# DEVELOPMENT HEARING OFFICER

**[PR-2023-009652](#)**

SD-2024-00148 Vacation of Right of Way

Vacation of Public Right-of-Way

**7 PROPOSED TYPICAL SECTION - UNSER BLVD. AT INTERSECTION APPROACH**

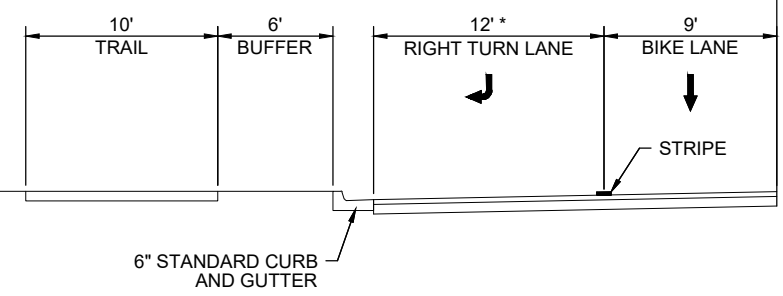
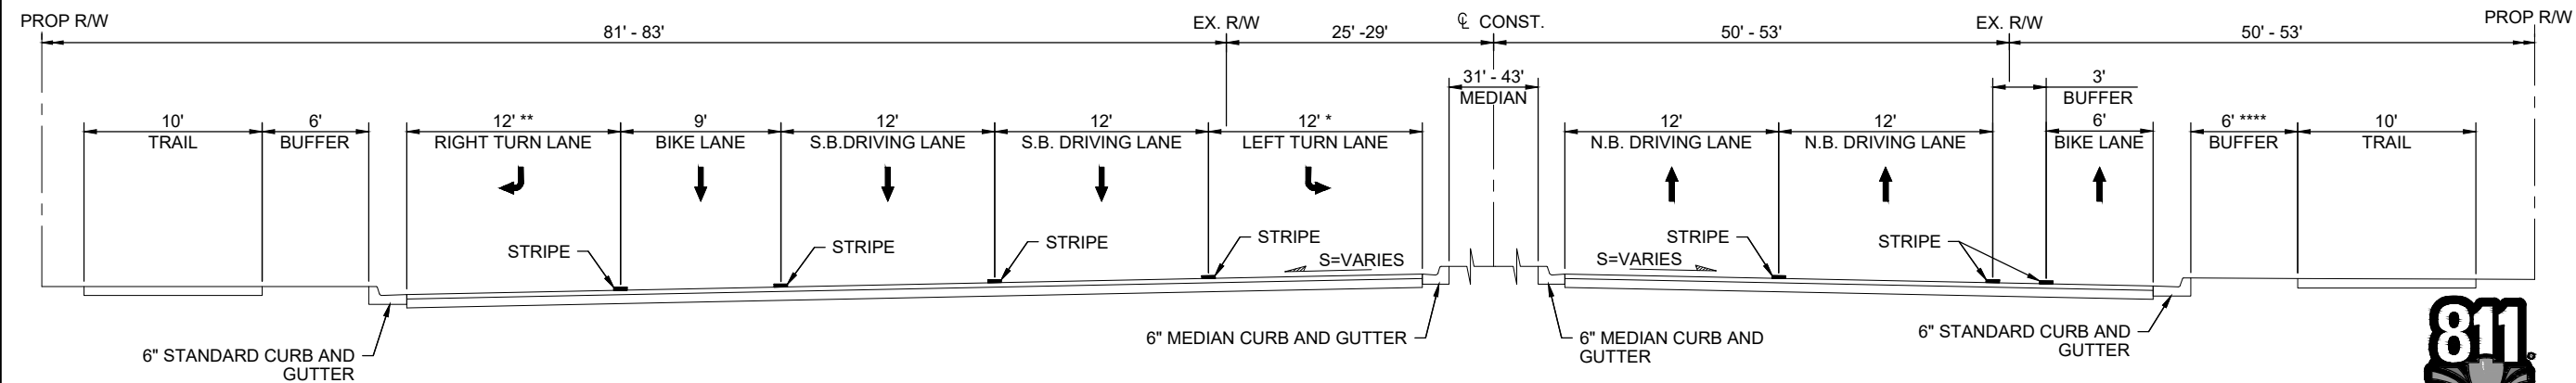
*There are proposed bike lanes along Unser, please ensure ROW will hold these and this is included in roadway widening. There is also a proposed paved trail along here. Please coordinate with Parks on whether this is planned for this side of the roadway. Paved trail can take the place of the required sidewalk.*

**TRACT 1A
A REPLAT OF
THE WESTERLY PORTION OF TRACT 1
SUMMARY PLAT, 68.75 ACRE TRACT
& 66.15 ACRE TRACT
PARADISE HILLS, TOWN OF ALAMEDA GRANT,
CITY OF ALBUQUERQUE, BERNALILLO COUNTY,
NEW MEXICO**

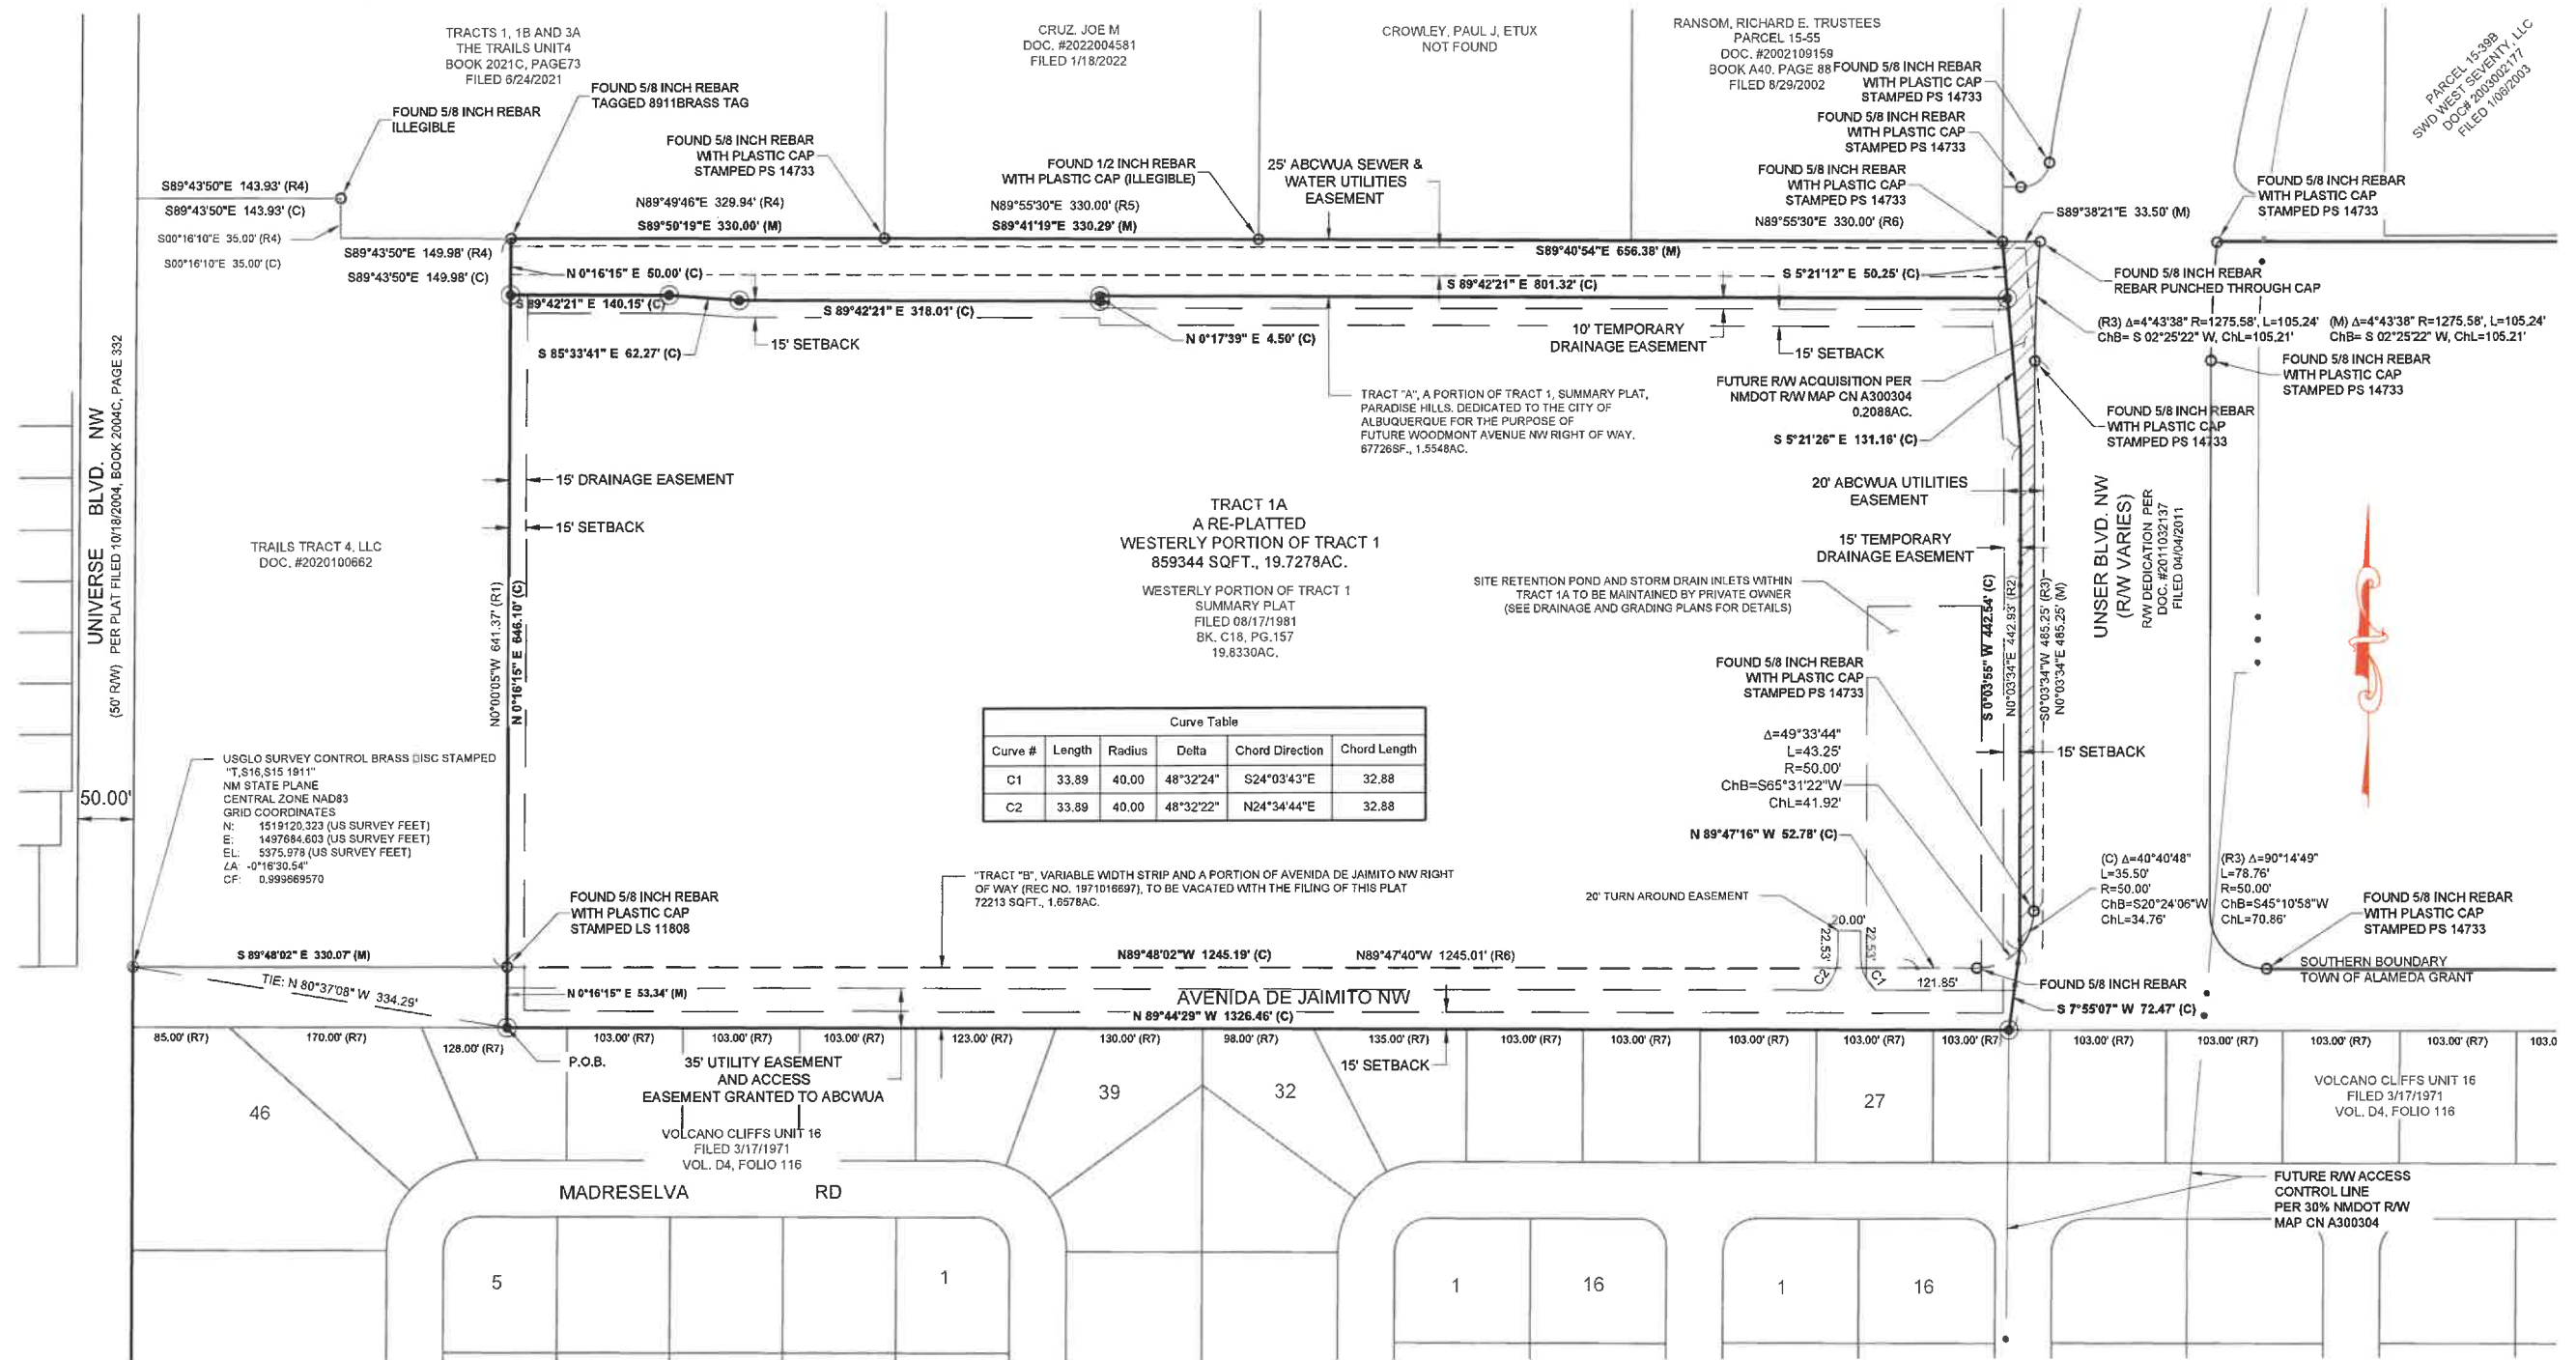
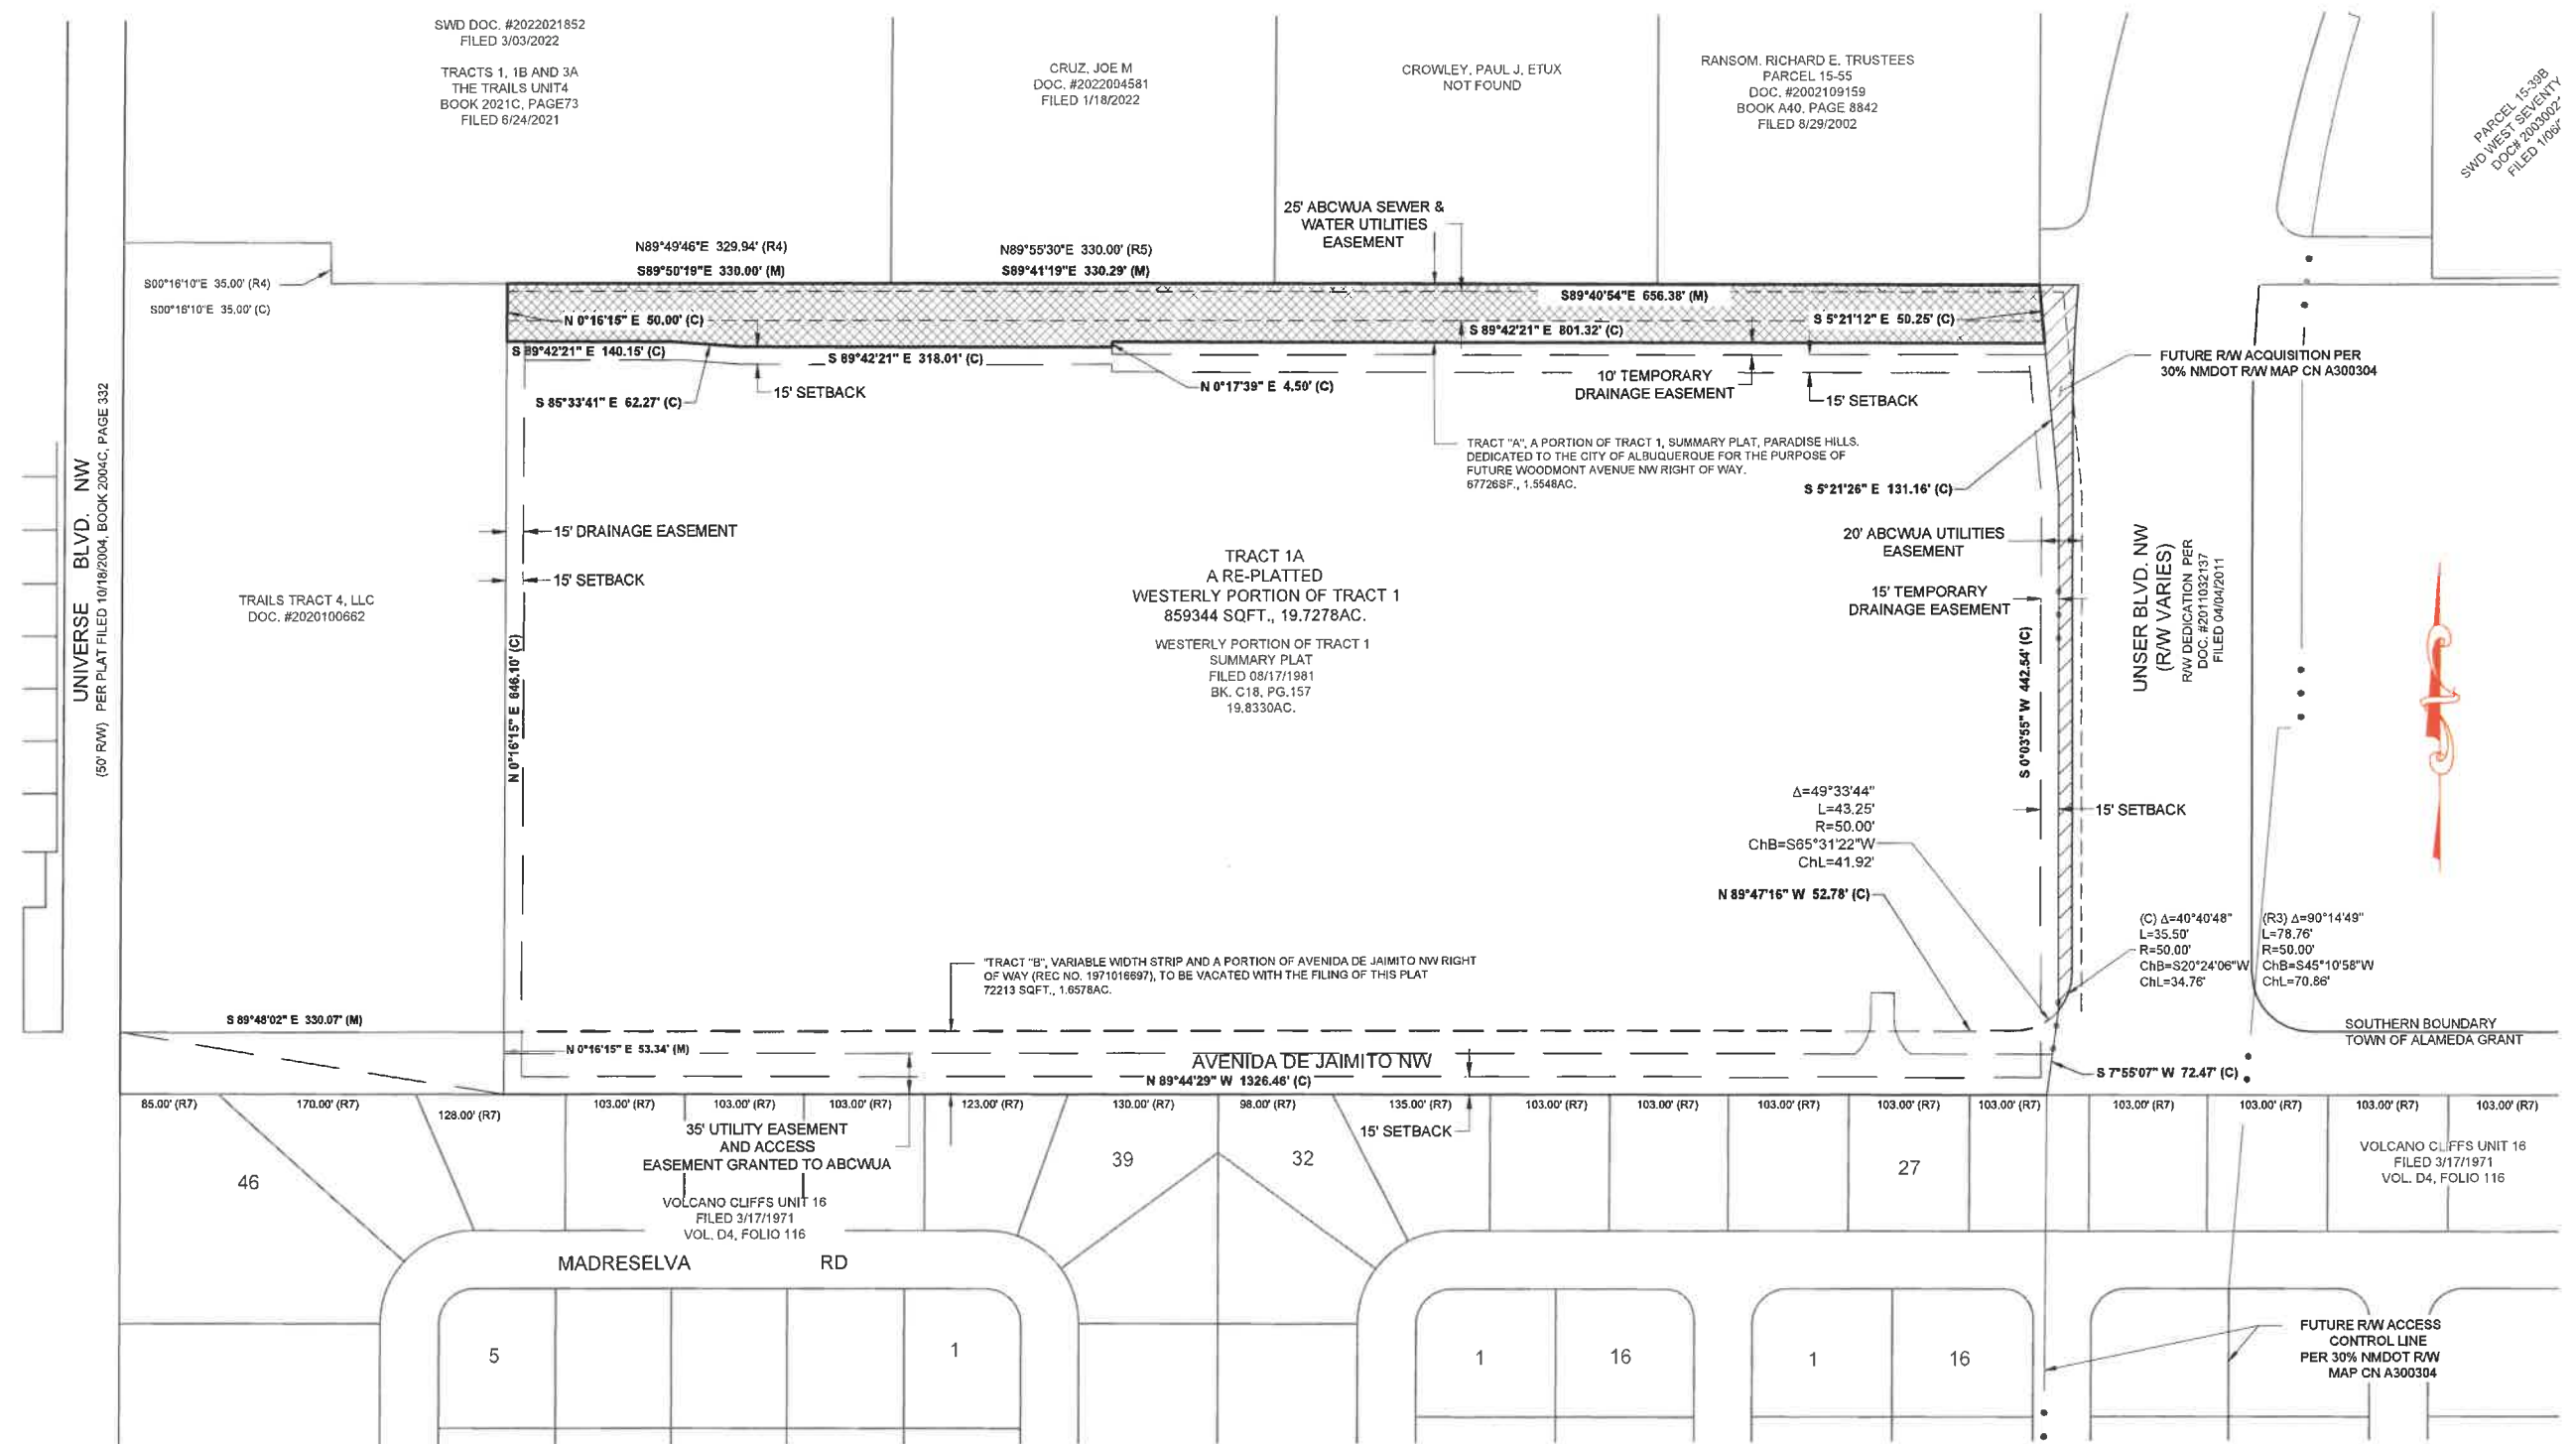
- Please explain and confirm the details of the Vacation request for the DHO.
- **Confirm how utilities that were planned for Avenida de Jaimito will still be accommodated in the corridor that is being vacated. Planning seeks response from WUA.**

- Please continue to coordinate the purchase and sign-off with Real Property Division of DMD.
- The Project and Application numbers must be added to the Vacation exhibit.

*Woodward is a proposed Major collector within a center and will require construction of the half of the roadway fronting this property including curb and gutter, required 10' sidewalk with 5' – 6' landscape buffer. Please list proposed ROW width to ensure it meets requirements listed in the DPM. There is also a proposed paved trail along here. Please coordinate with Parks on whether this is planned for this side of the roadway. Paved trail can take the place of the required sidewalk.*
